From: Contact Centre (CRM) <contact@ribblevalley.gov.uk>
Sent: 31 July 2022 22:41
To: Planning
Subject: Planning Application Comments - 3/2022/0664 FS-Case-441028210

Planning Application Reference No.: 3/2022/0664

Address of Development: 16 Hollies Road, Wilpshire, BB1 9NA

Proposal: Proposed two storey rear extension to form additional living accommodation

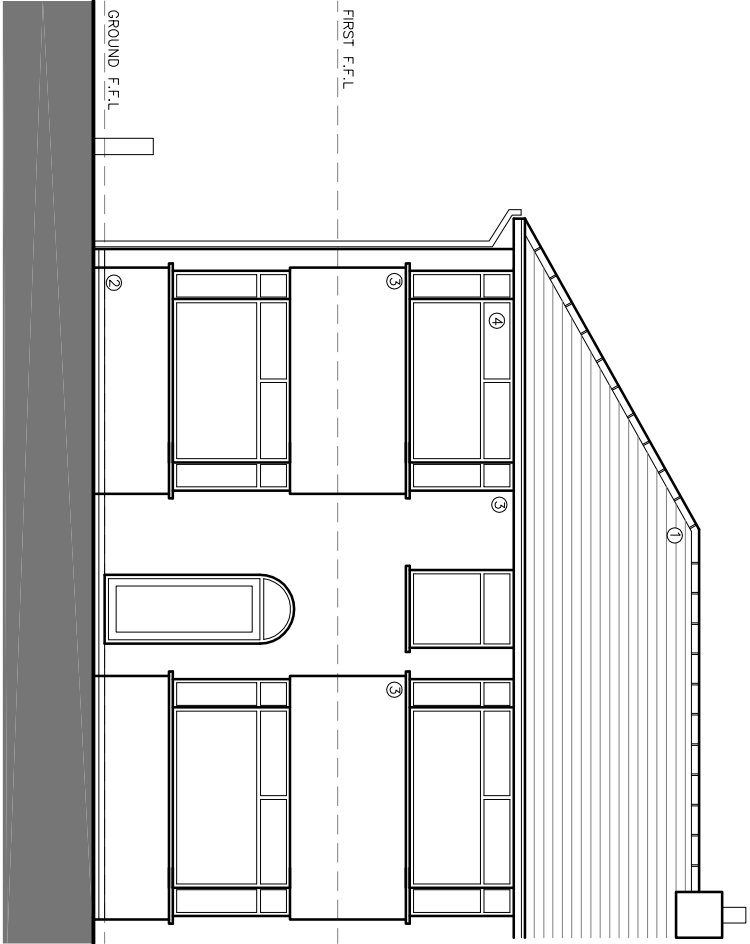
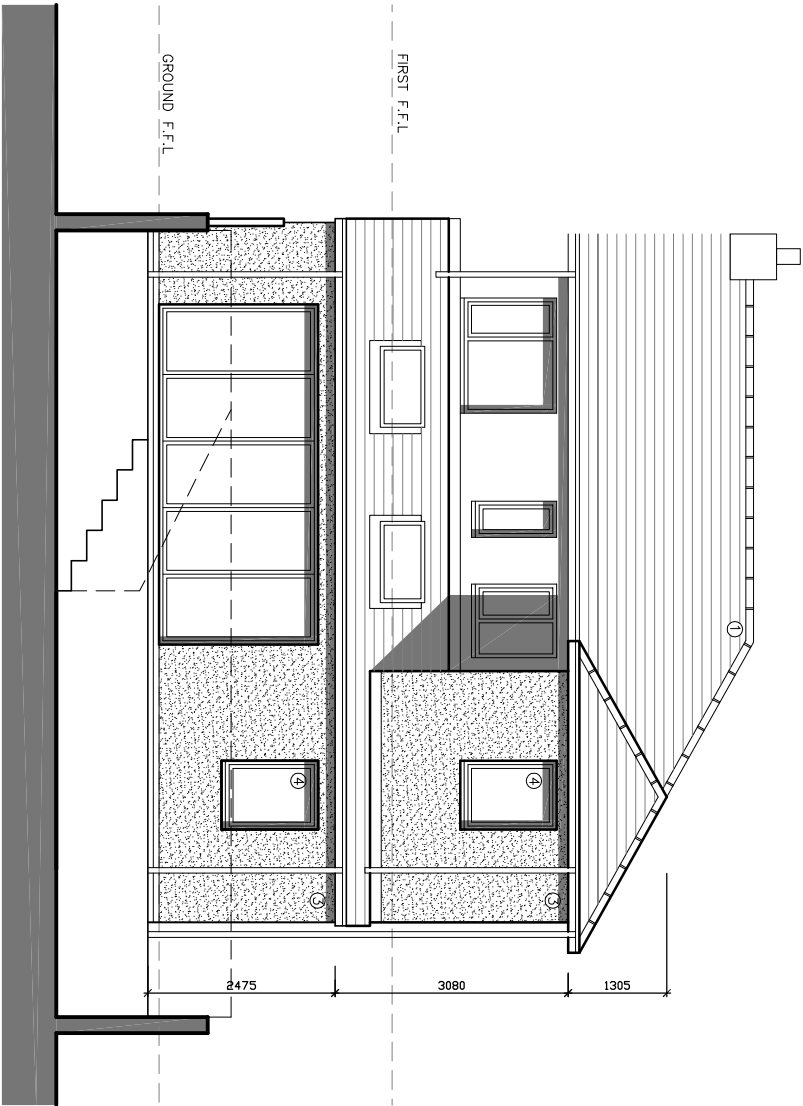
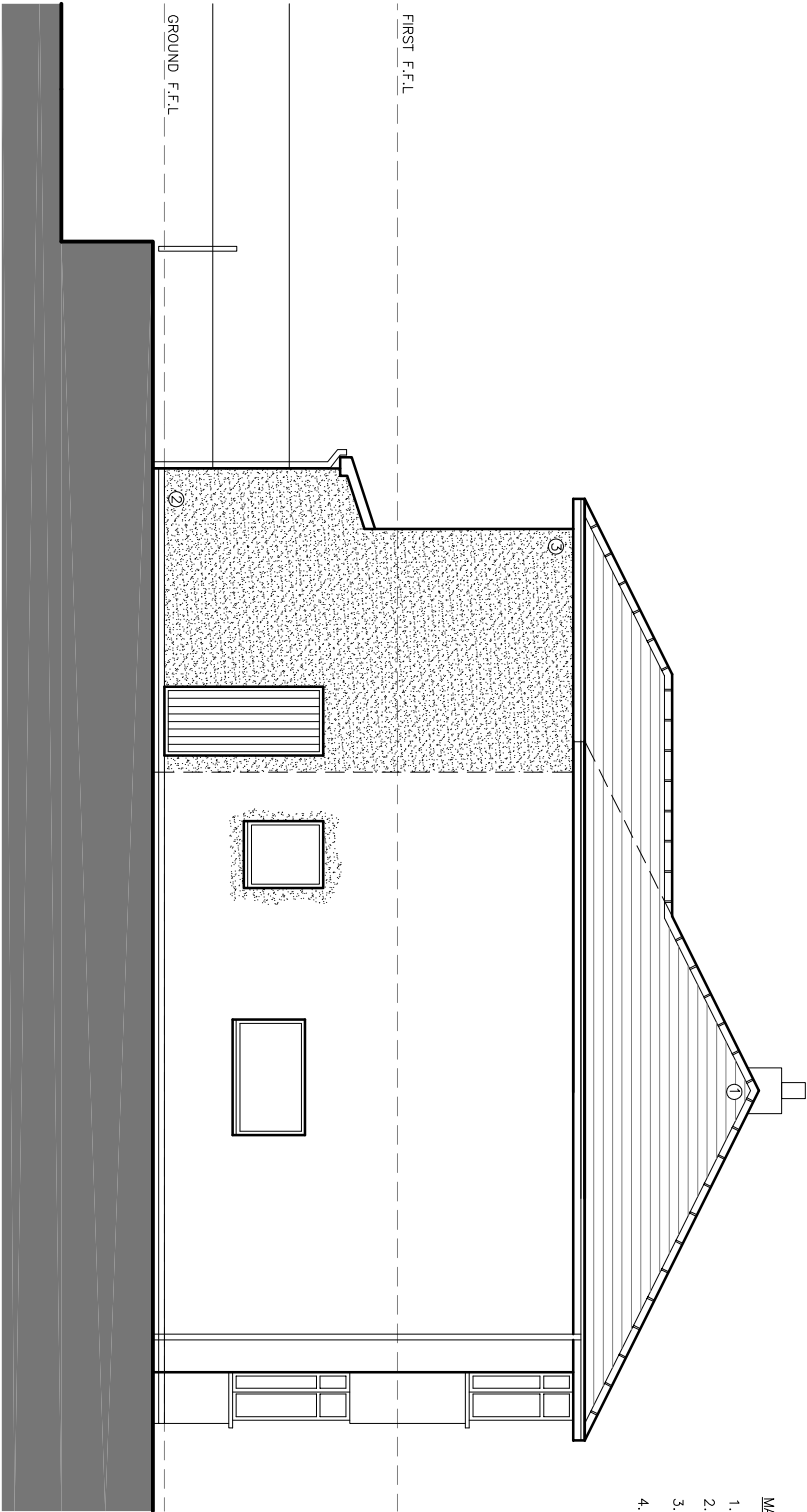
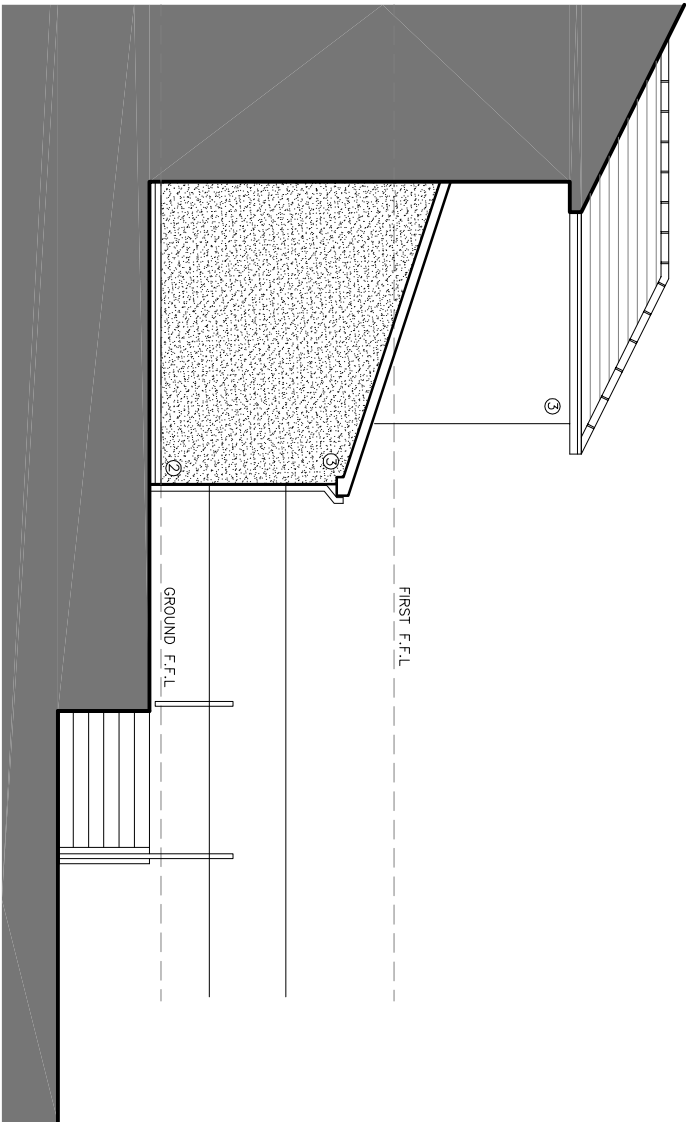
4. Patio area height – the development as detailed maintains the patio area at the same height as the extension. This requires a rise in height of the garden foundations by approx. 1.5m. The development then shows the boundary structure / fence at approx. 2m height. [REDACTED]

5. The plans show materials / finish to be pebble dash. [REDACTED] this would not be in-keeping [REDACTED]

We do appreciate that the development will benefit the space and living conditions at No.16. We Suggest that the extension is reduced in distance [REDACTED] and that the patio extension beyond the building extension is at the lower No.16 garden level so as to not [REDACTED]
[REDACTED]

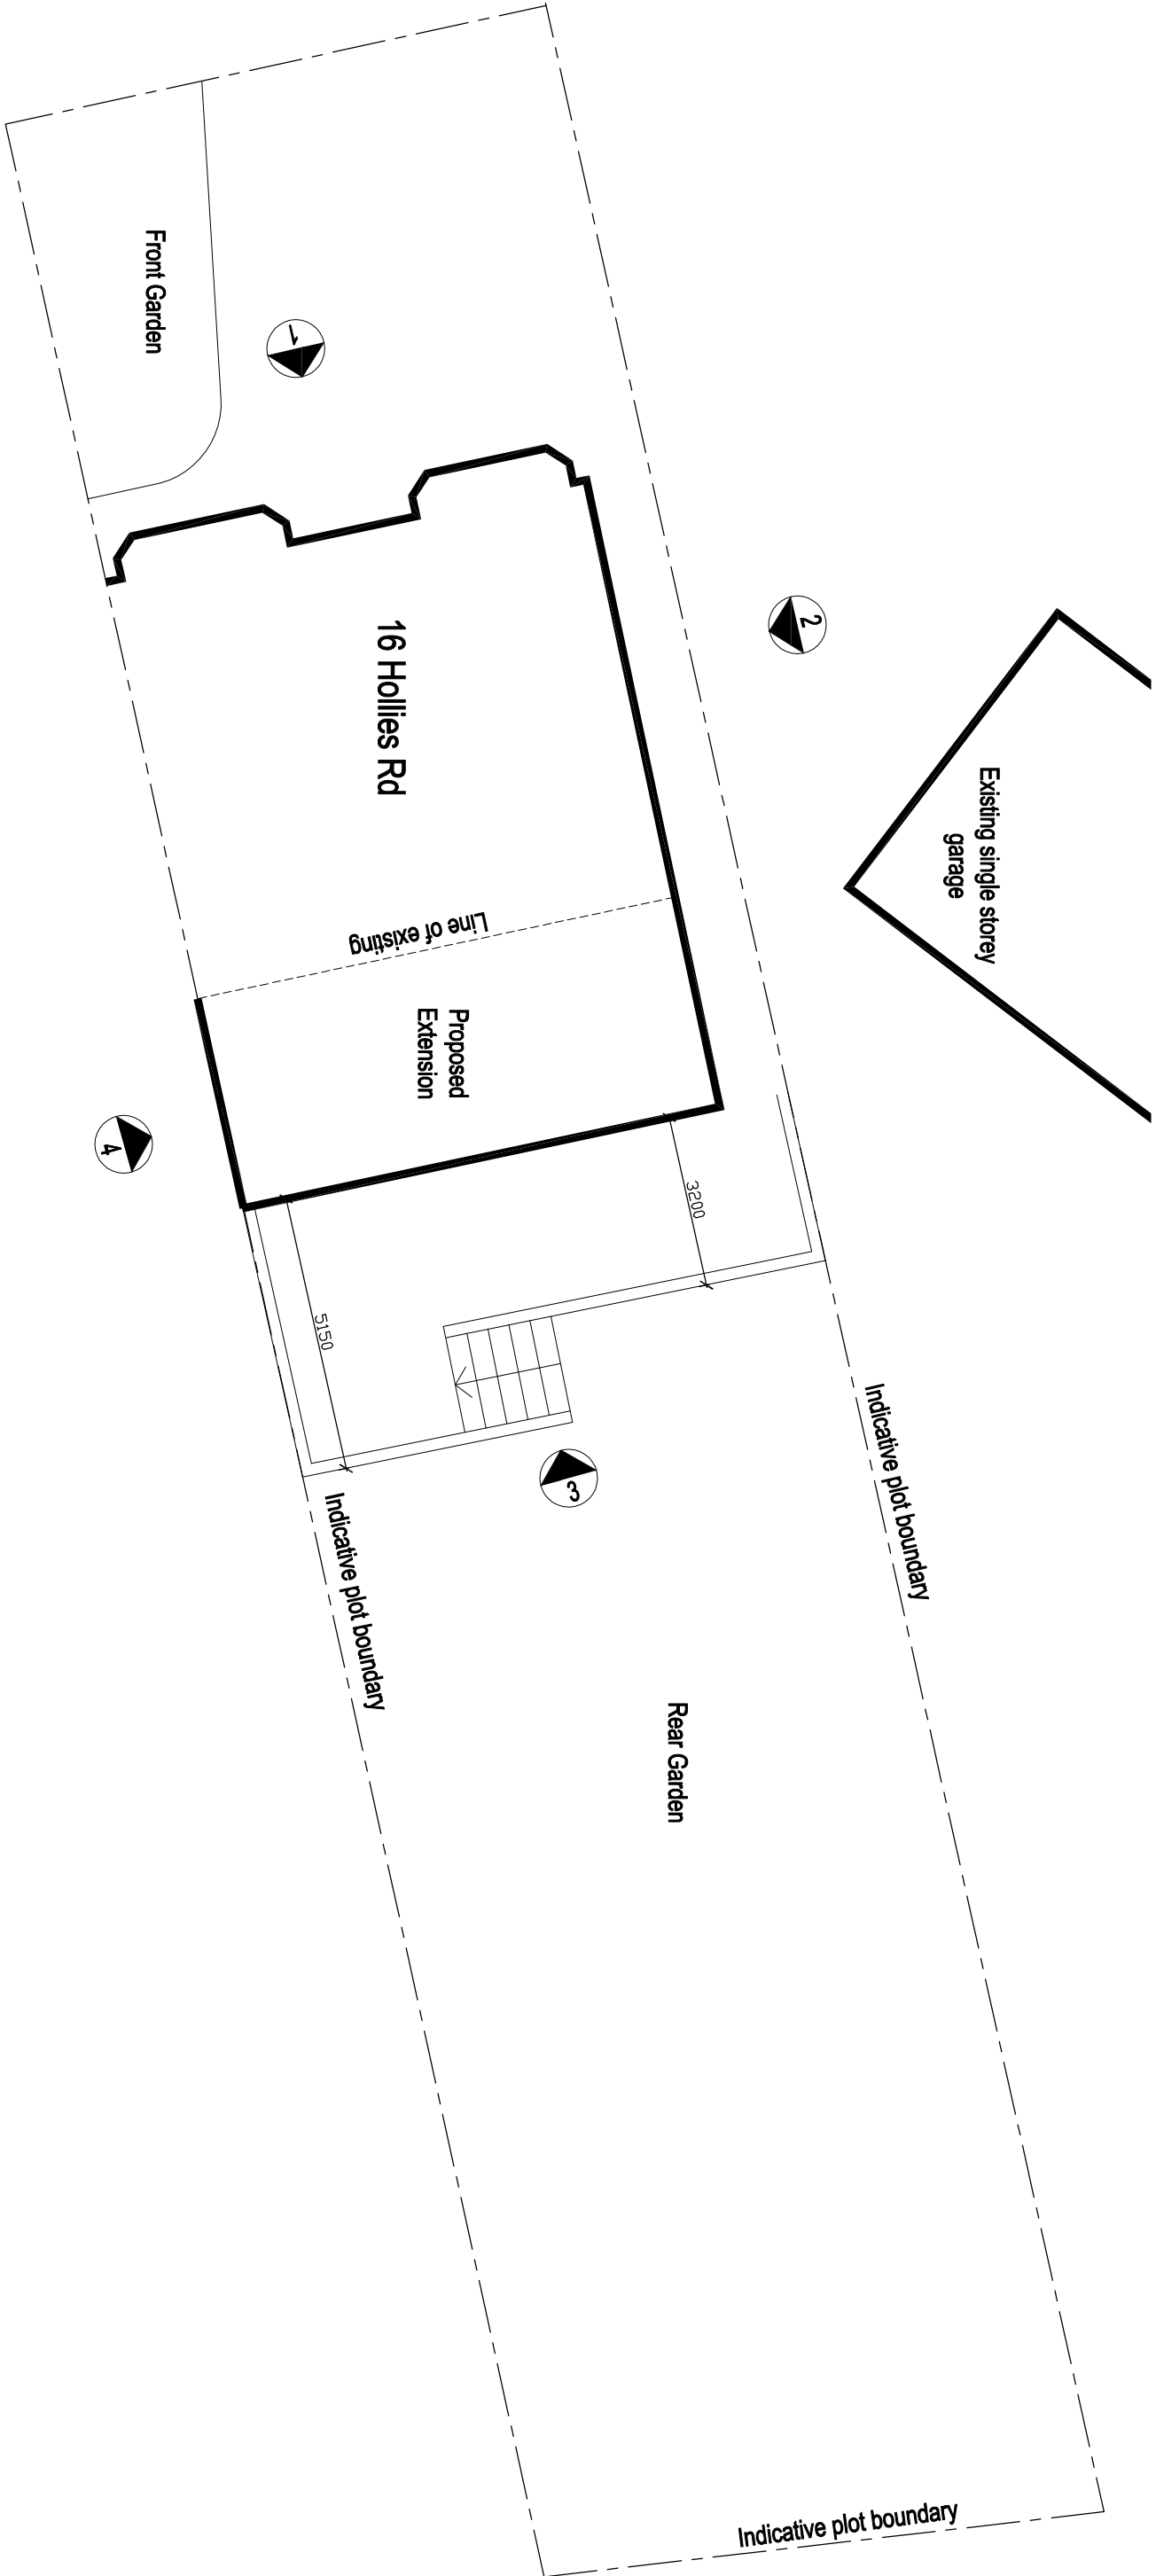
patio area requires building up the lower garden with foundations of a height of 2m, preventing adequate opportunity for drainage [REDACTED]
